From: [Holly Duncan](#)
To: [Jeff Watson](#)
Subject: RE: BL-11-00003 Brown
Date: Tuesday, February 22, 2011 2:53:15 PM

From: Jeff Watson
Sent: Tuesday, February 15, 2011 9:14 AM
To: Christina Wollman; Brenda Larsen; Jan Ollivier; Holly Duncan
Subject: BL-11-00003 Brown

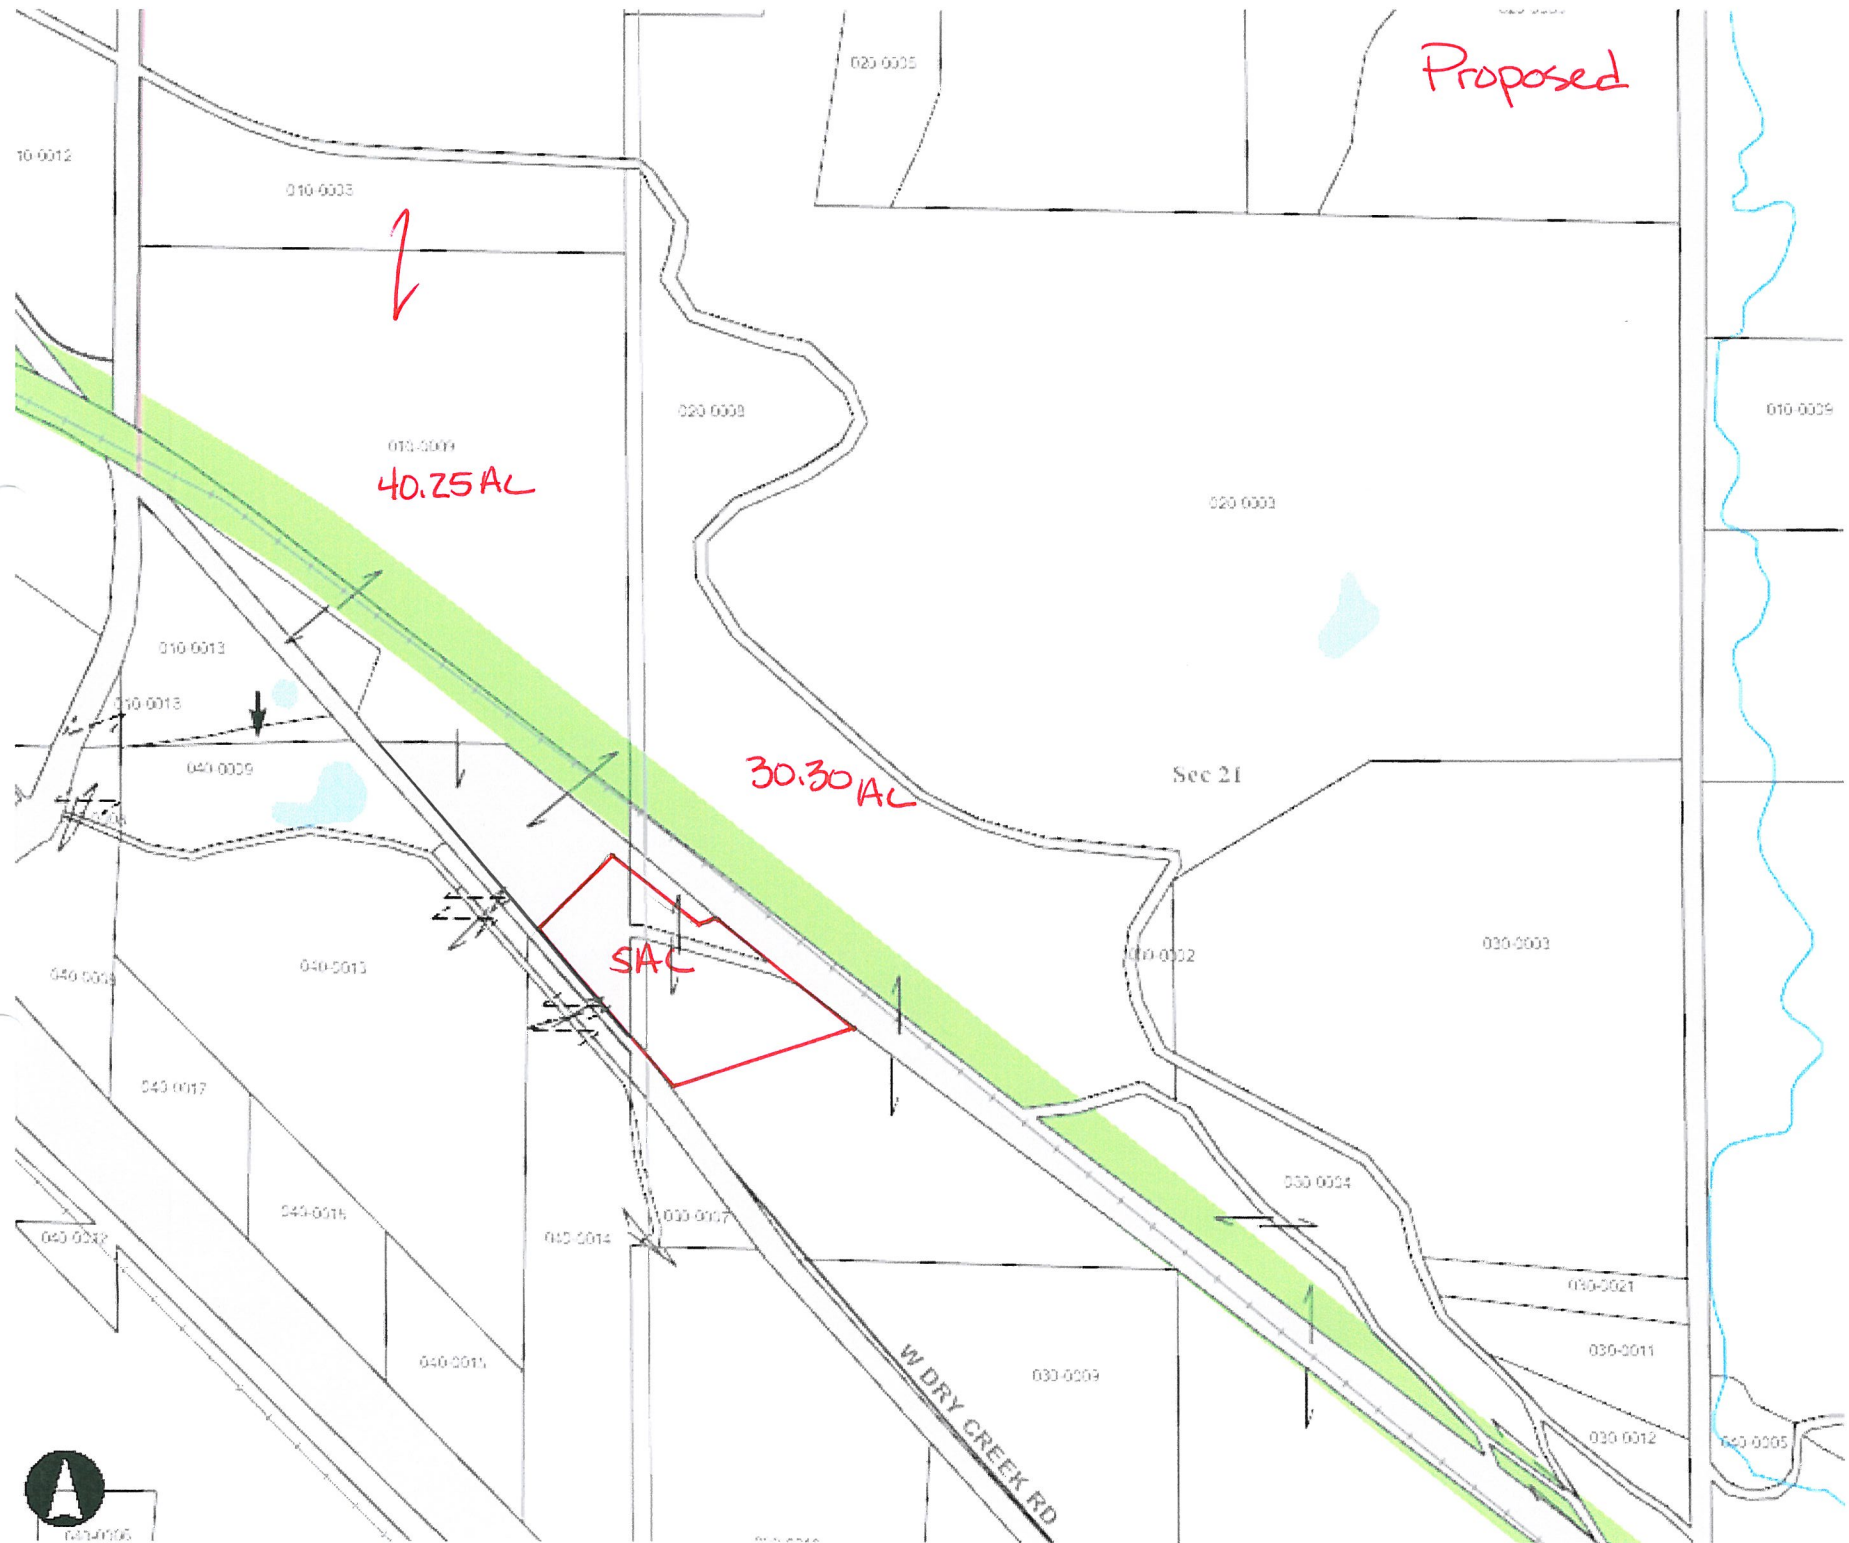
This looks OK as long as the proposed lines don't come within 50 feet of any existing wells. The 5 acre piece has a lot of structures and it is difficult to determine where the well is located.
